Applicant Name: Mike Abele
Applicant Company: Stratus Team, LLC/Morris & Associates
Applicant Email: mike.abele@stratusteam.com
Project Name: [Kroger Fulfillment Center - Site Development Plan](#)
Project ID Number: 2011731

The City of Fountain has completed its review of the Kroger Fulfillment Center - Site Development Plan for the property generally located at 702 BANDLEY DR. The following are items that need to be corrected and/or modified. Once you have made the revisions, please resubmit all project documents through the project portal, using the 'Review and Resubmit' button provided on your project page. Please provide a response to all comments as part of the resubmittal process. You can "reply" on the "response tab".

C-201B

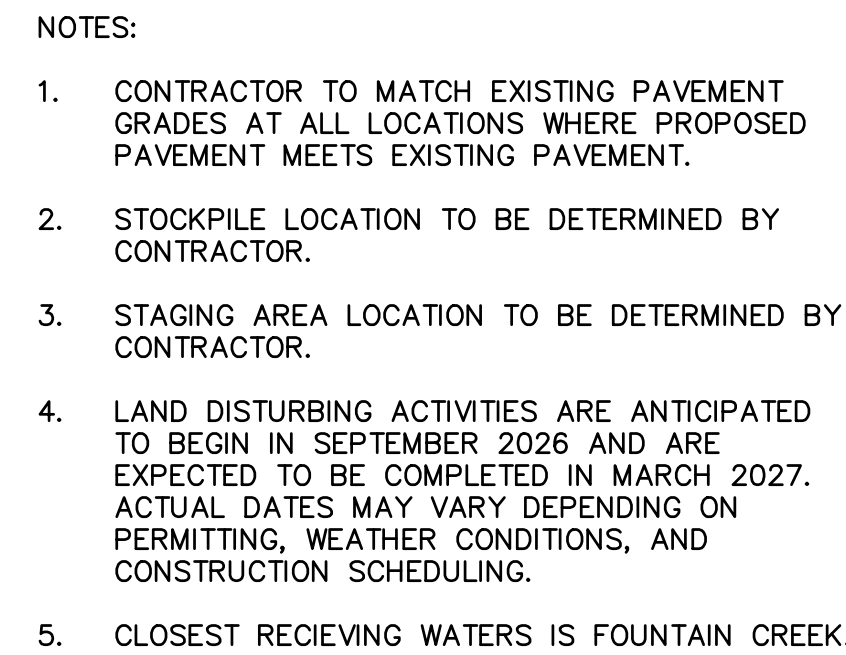
need cover sheet details of land uses size of building setbacks
impervious area, need a clear site plan with setbacks to the
building

C-203

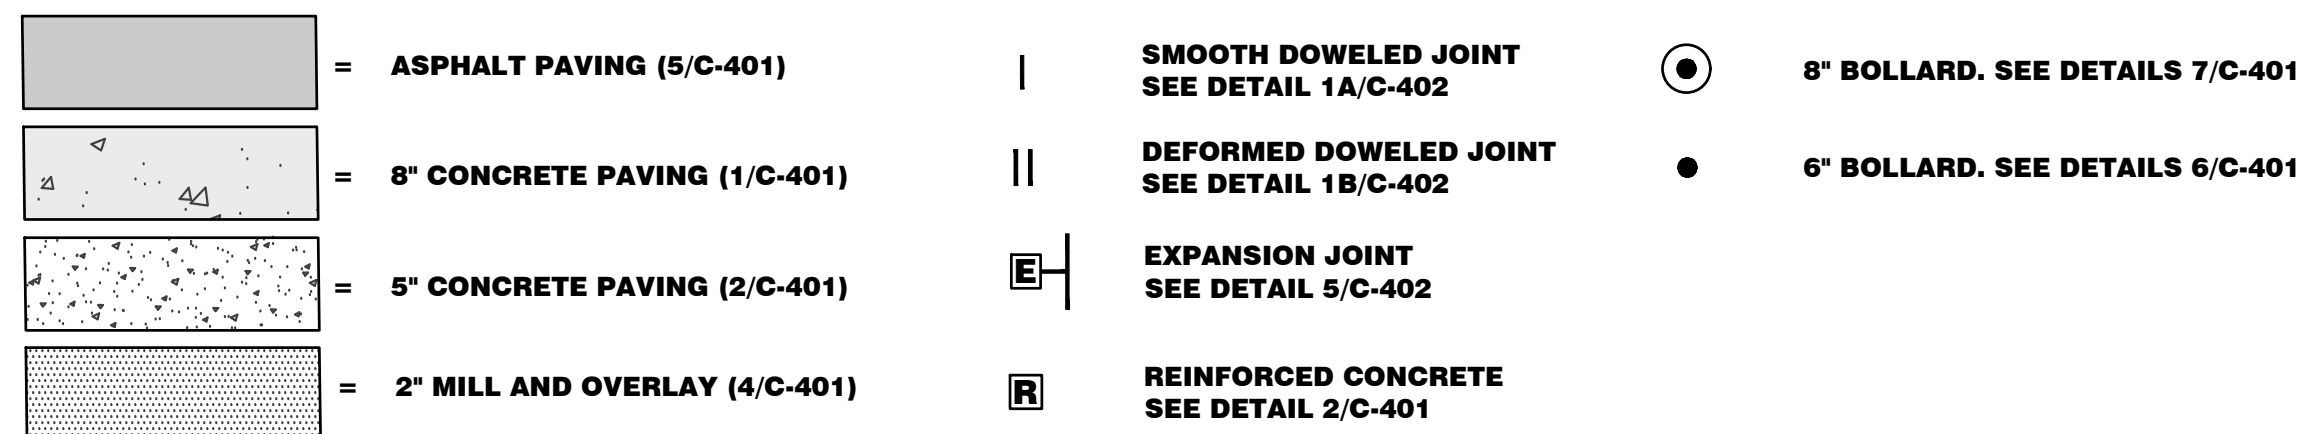
work out requirements for arch regs on dockzilla, maybe admin
relief

consider lining the approach to the dockzilla with trees in lieu of
arch requirements

[Fountain Sanitation District](#) label as SDR-35, not PVC
Jonathan Moore
7193825303
jonathanm@fsd901.org

[Fountain Sanitation District](#) label all cleanouts as 2-way
Jonathan Moore
7193825303
jonathanm@fsd901.org

label as 2-way cleanout

label as private, but not required by FSD, may be removed

label finish floor elevation and invert elev.

all clean-outs must have a traffic rated lid.

Sanitary pipe material callout updated.

All clean-out labeled as 2-way.

All clean-outs labeled as 2-way.

Manhole label has been revised.

Finish Floor elevation and invert elevation added to sheet C-203.

Utility note added.

C-406

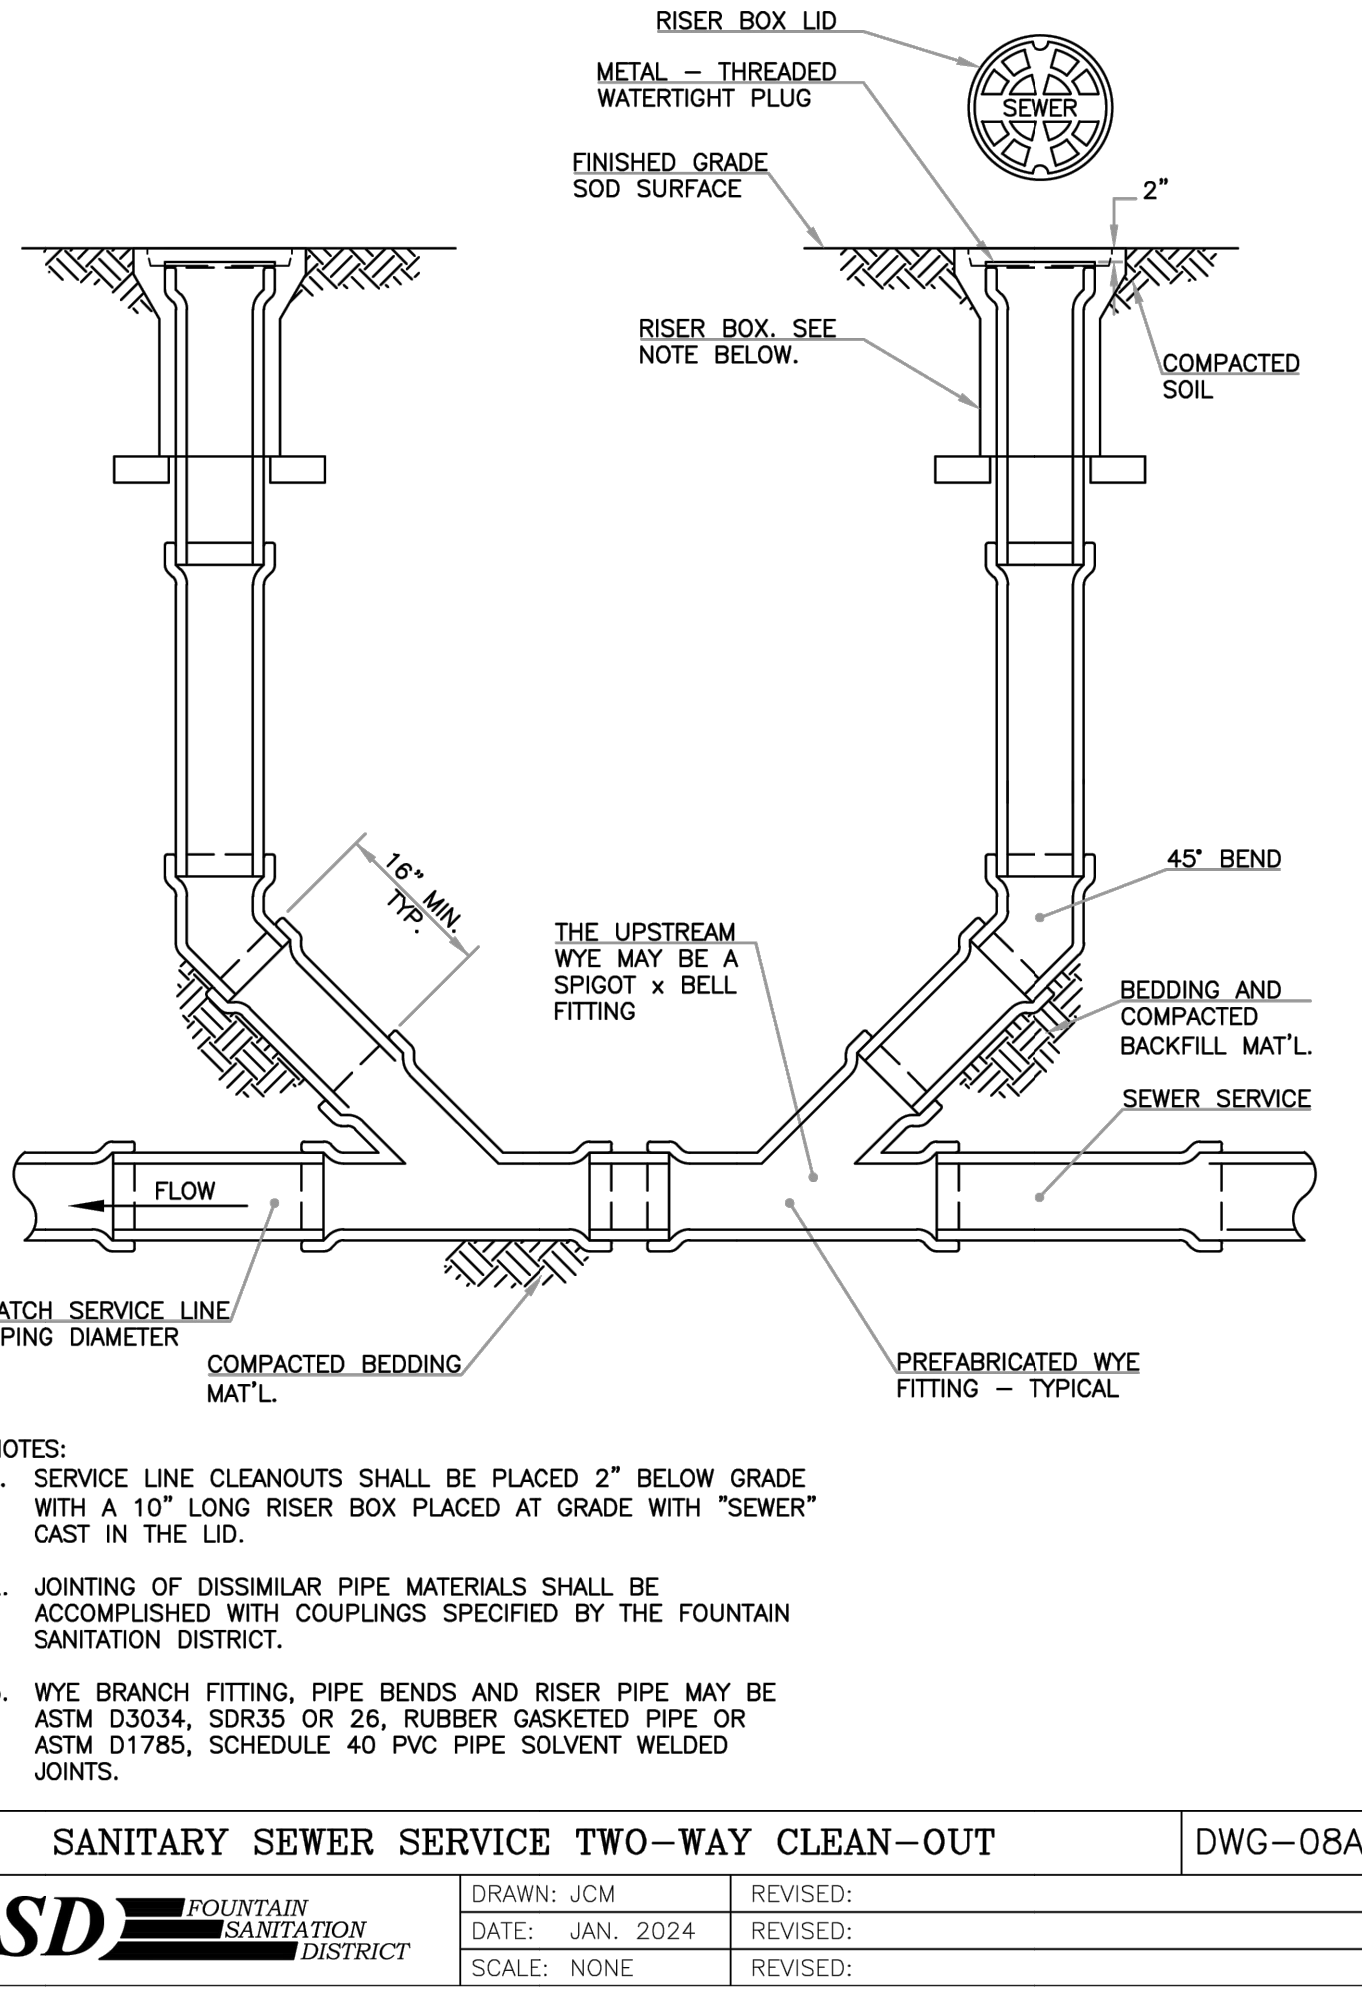
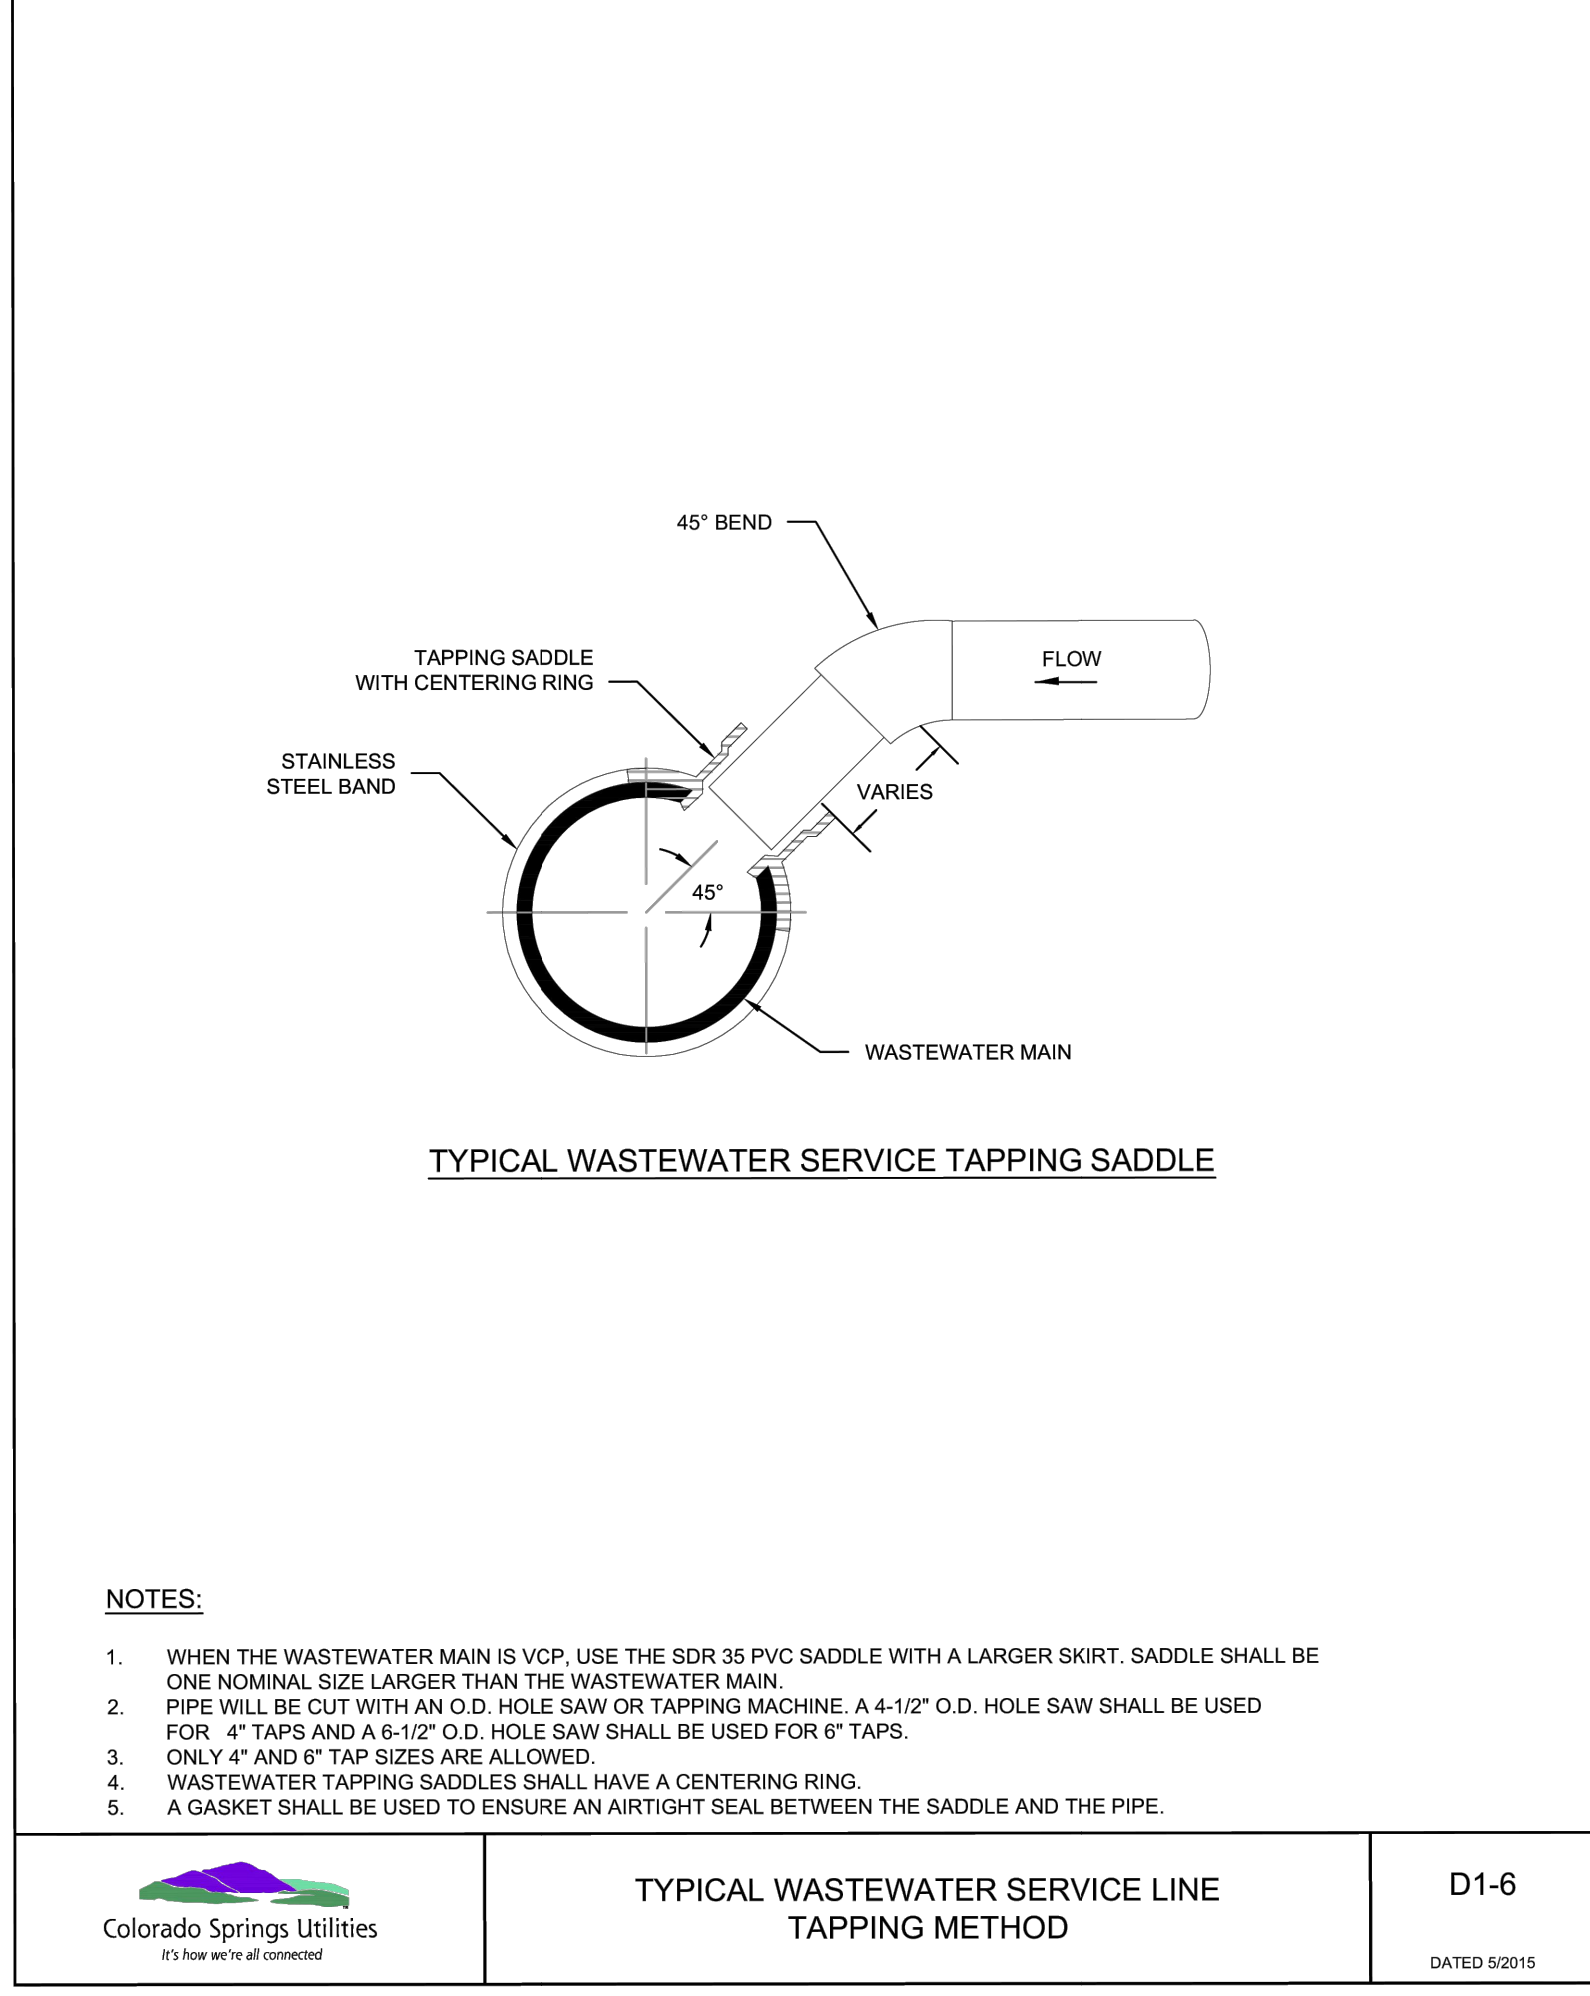
[Fountain Sanitation District](#) change fsd detail to dwg-05
Jonathan Moore
7193825303
jonathanm@fsd901.org
